**Your Ref:** OWPC14638  
**Our Ref:** BR/194/17/PL 30-06-2017  
**Please ask for:**  
Richard Temple

Demolition of the existing Foreshore office & decommissioning of existing underground toilets. New purpose built unisex toilet block including urinals, baby changing facilities & accessible WC, plus a separate beach office with public information point & first aid facilities. All located on the existing seafront promenade.

Promenade Opposite Clarence Road The Esplanade Bognor Regis

Thank you for your internet representation made on 20th July 2017 which has been recorded as '**an objection**' with the comments as follows:

DRAWING
Proposed Elevations North-South

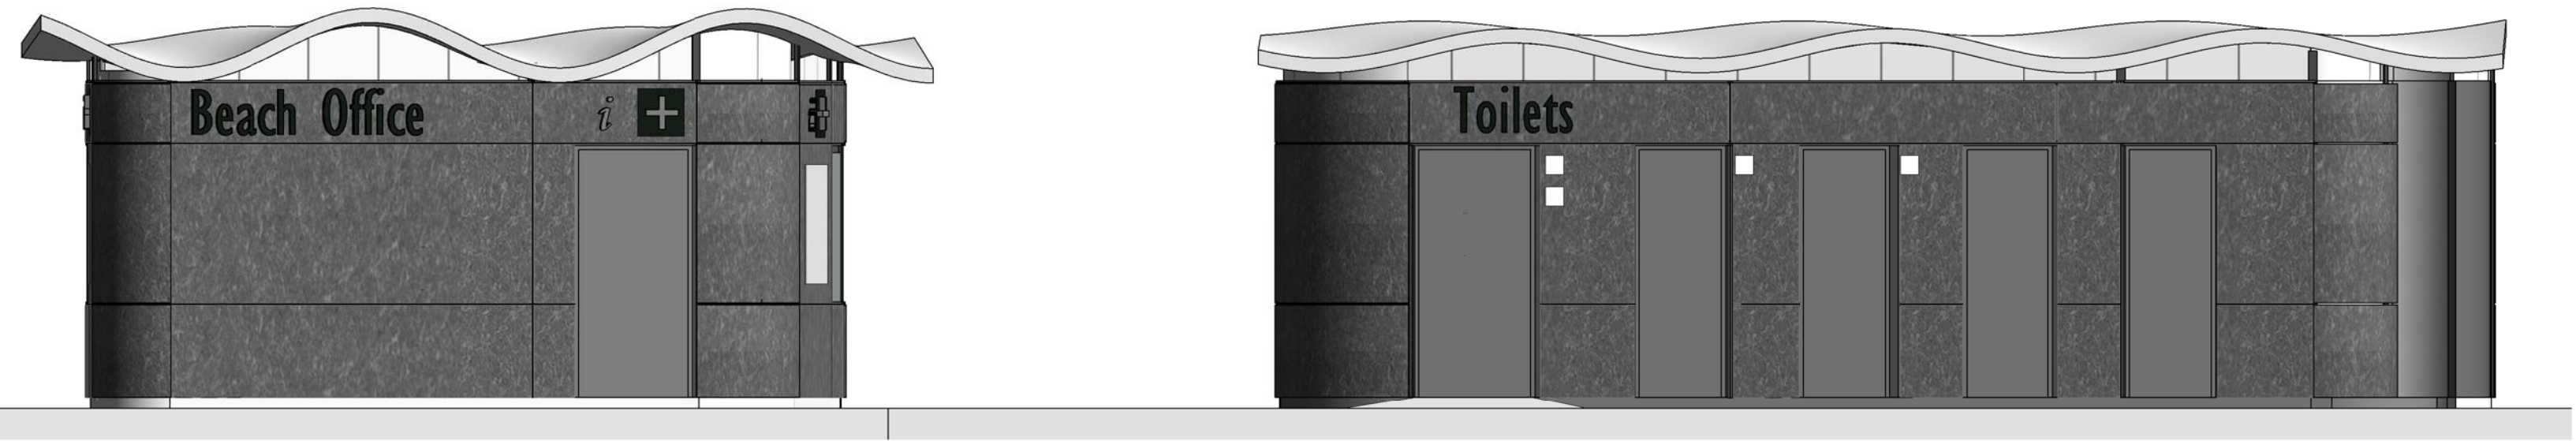
*Planning shows position opposite Clarence Road, press photo shows position opposite Esplanade Grande. Please clarify. Unacceptable to have toilet doors opening in full view of residents, why not on south side? Also North side would be lack of access for wheel chairs and buggies*
